From: Sarah Sutcliffe [REDACTED]
Sent: 01 February 2019 13:05
To: Anita Gardner
Cc: Mark Wild
Subject: Land South of Cornfields Close, Littlehampton, BN17 6LD (REF: HA/2018/120921/01-L01)
Importance: High

We are writing in connection with the Environment Agency's planning response regarding the above named site. The EA has recommended a number of conditions (see below). We are seeking clarification on a few points, as detailed in green below.

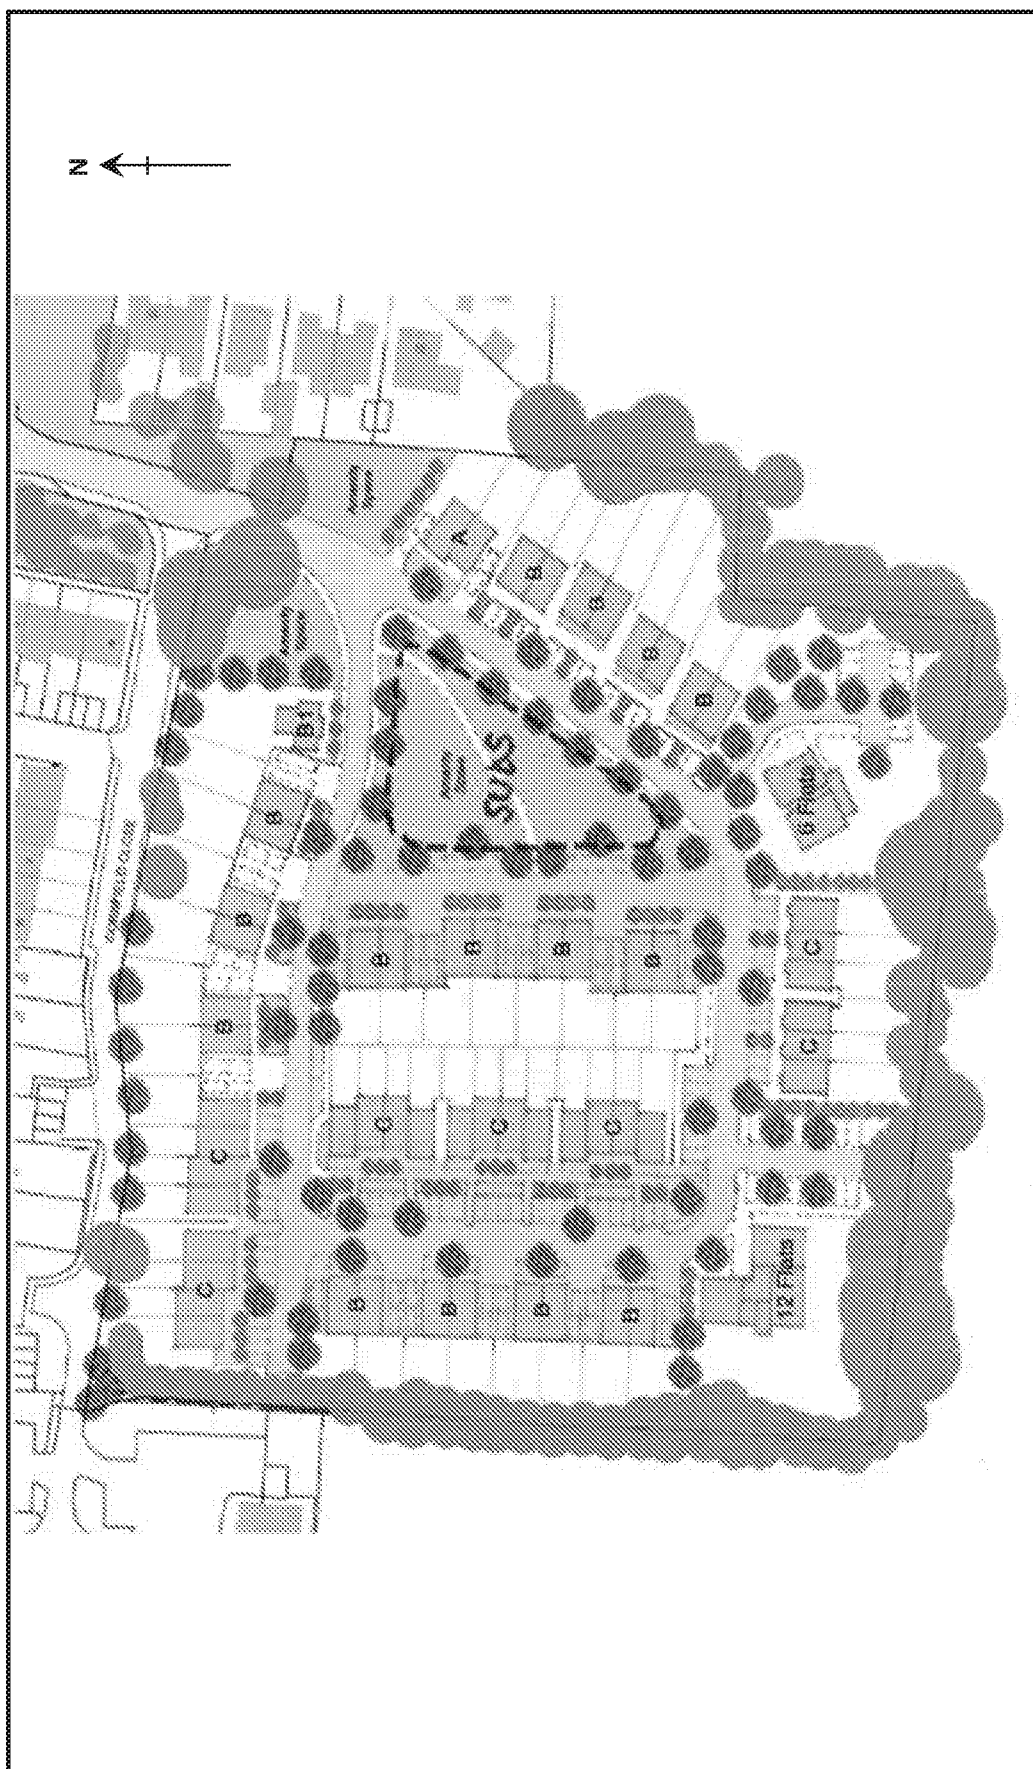
The previous use of the proposed development site as Brick Kiln and Landfill presents a high risk of contamination that could be mobilised by surface water infiltration from the proposed sustainable drainage system (SuDS). This could pollute controlled waters. Controlled waters are particularly sensitive in this location because the proposed development site is located upon a principal aquifer. In light of the above, we do not believe that the use of infiltration SuDS is appropriate in this location. We therefore request that the above planning condition is included as part of any permission granted. Without this condition we would object to the proposal in line with paragraph 170 of the National Planning Policy Framework because it cannot be guaranteed that the development will not be put at unacceptable risk from, or be adversely affected by, unacceptable levels of water pollution.

Previous correspondence with Simon Deacon at the Environment Agency (see attached), detailed a soakaway construction methodology for the site that entailed storm water being dispersed via a chamber/crate system which would be designed so that the discharge would be vertical only into the superficial natural uncontaminated soils. Full details are presented in the FRA submitted by Glanville referenced: CV8171223/SMcN/023, with an extract below:

All surface water run-off generated by hardstanding areas within the site will be conveyed to a soakaway, consisting of geocellular crates. The soakaway will be located close to the centre of the site, in the open public space. In accordance with EA recommendations, made ground will be removed from the area surrounding the soakaway before the installation. The base of the geocellular crates will be located at approximately 4.5m bgl, below levels where made ground is currently found. The sides and top of the soakaway will be lined, in order to prevent the mobilisation of any potential residual contamination from horizontal discharge from the soakaway. The design of the soakaway is therefore in accordance with EA guidance and site-specific recommendations and will not mobilise any residual contaminants within the site soils which may adversely affect groundwater.

A sketch of the proposed design principle is attached. As stated above, the infiltration will only be vertically into the natural uncontaminated soils to mitigate the risk to controlled water.
